Condition 5- surface water drainage

Condition 6- discharge of flows to watercourse

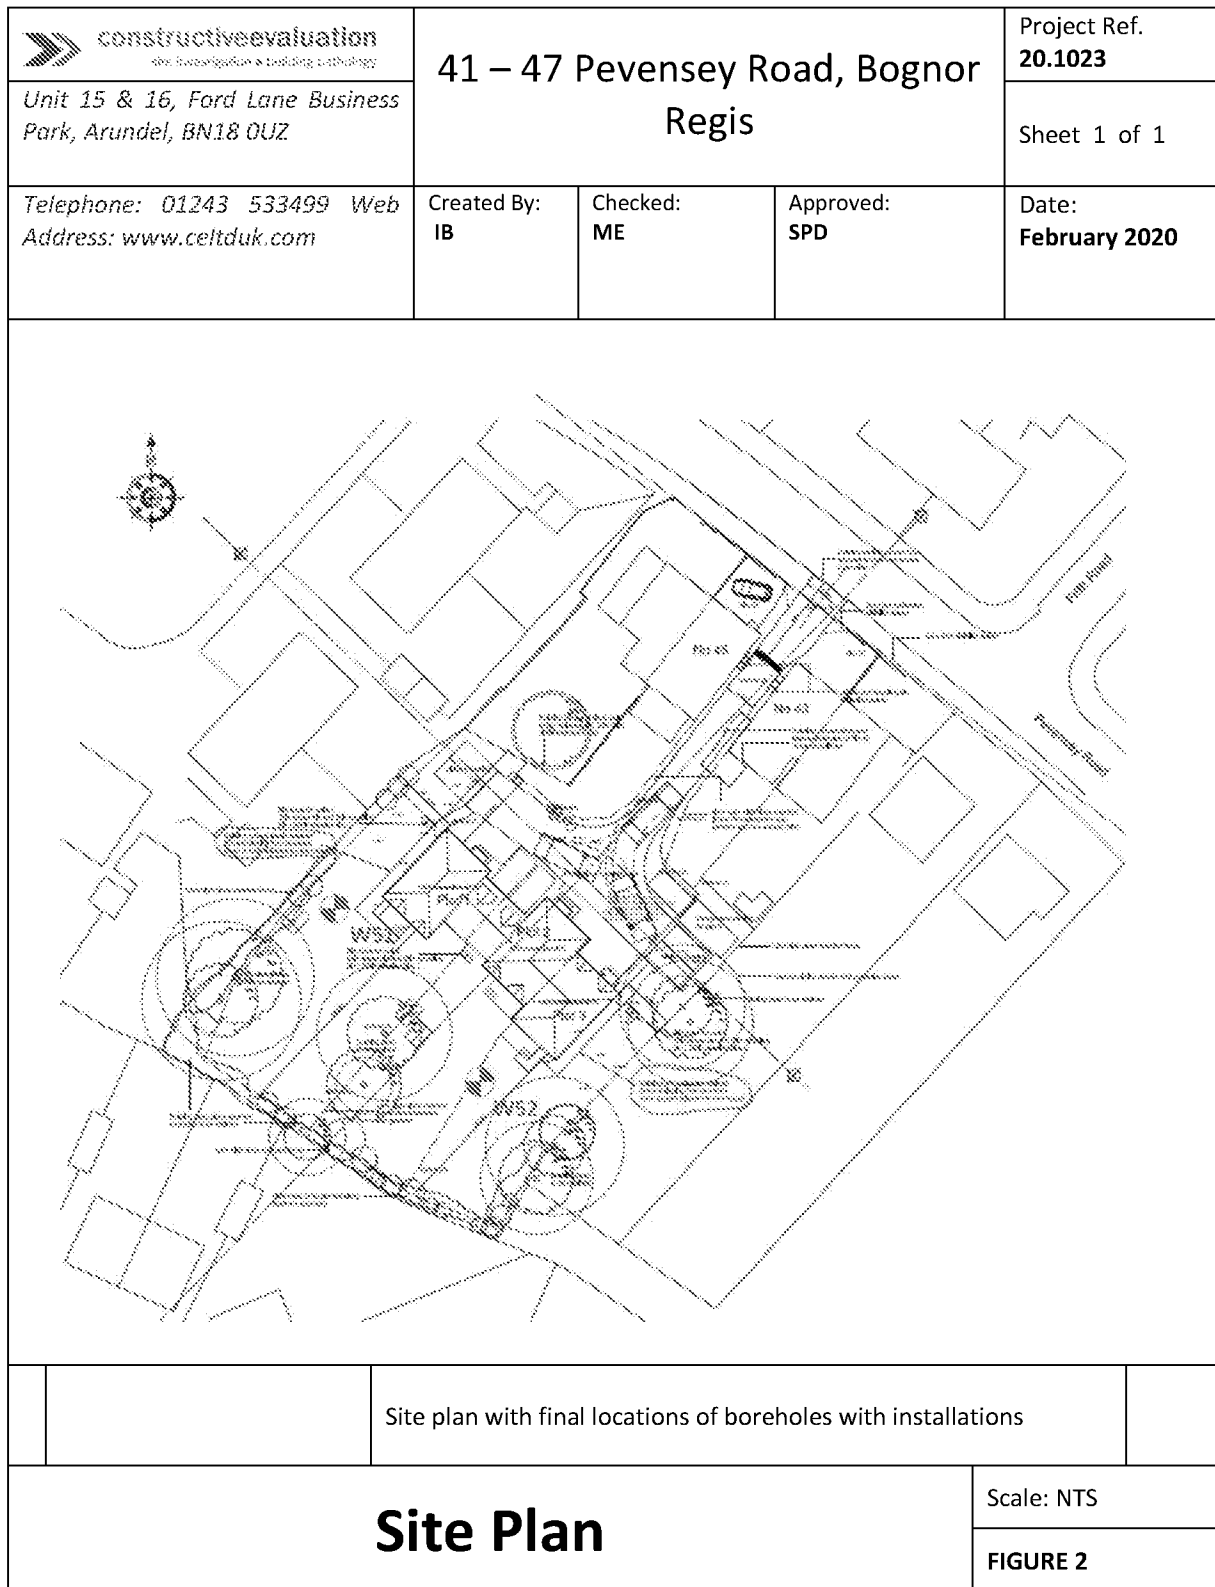
Whether the sub-base of the permeable paving is lined or not is dependent upon winter groundwater monitoring. Disappointingly this monitoring was only completed to the south west of the proposed dwellings and not in the area proposed for permeable paving. Given the differences in elevation and sensitivity of the site it is not appropriate to use these results to the north east of the proposed buildings. Therefore it is not possible to determine if the base needs to be lined and if attenuated discharge to watercourse is required.

The duration of monitoring was also exceptionally poor, covering only two weeks. Levels observed indicate that groundwater was found to be very close to surface level, no comment is made upon this in the application and infiltration is proposed.

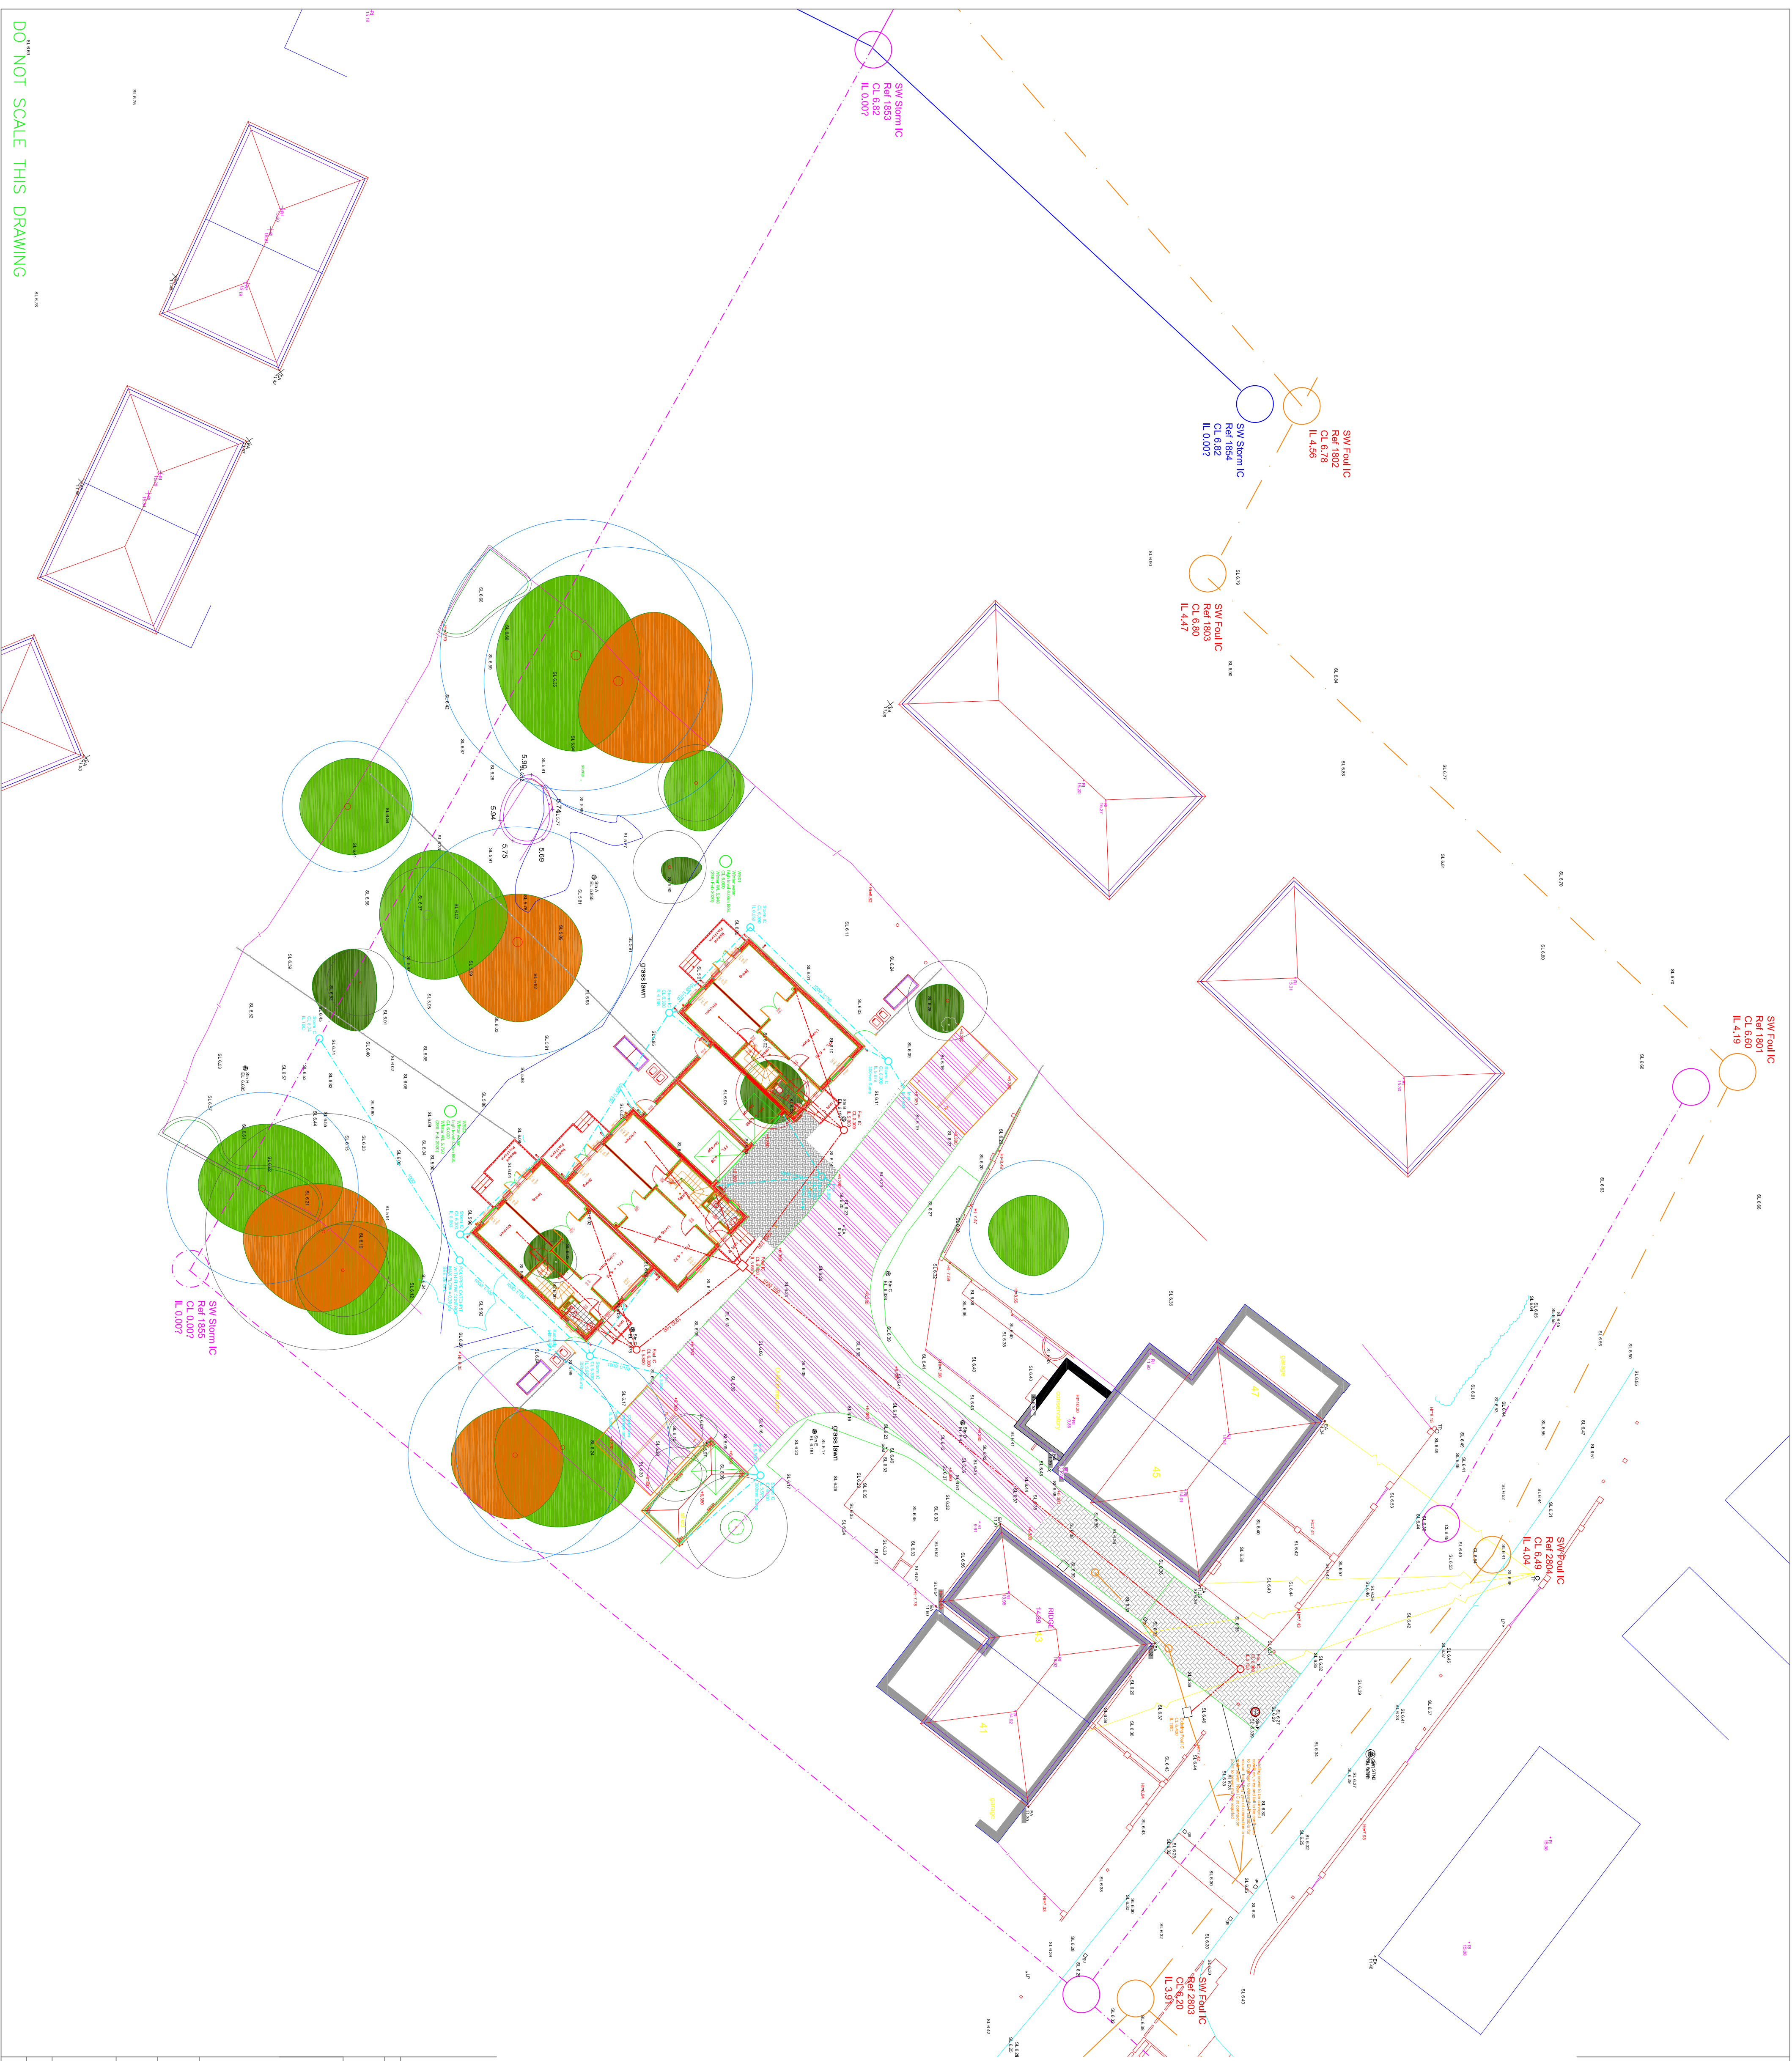
The documents submitted do not accord with the documents submitted to support the planning appeal. Details supplied to discharge this condition must tie in with this, specifically regarding levels and extent of permeable paving to ensure that flood risk is not increased elsewhere.

The discharge of condition application does not appear to acknowledge the requirement for providing flood mitigation and surface water drainage.

We also note that finish and formation levels must be shown on permeable paving and it must be accurately modelled to include any slope.
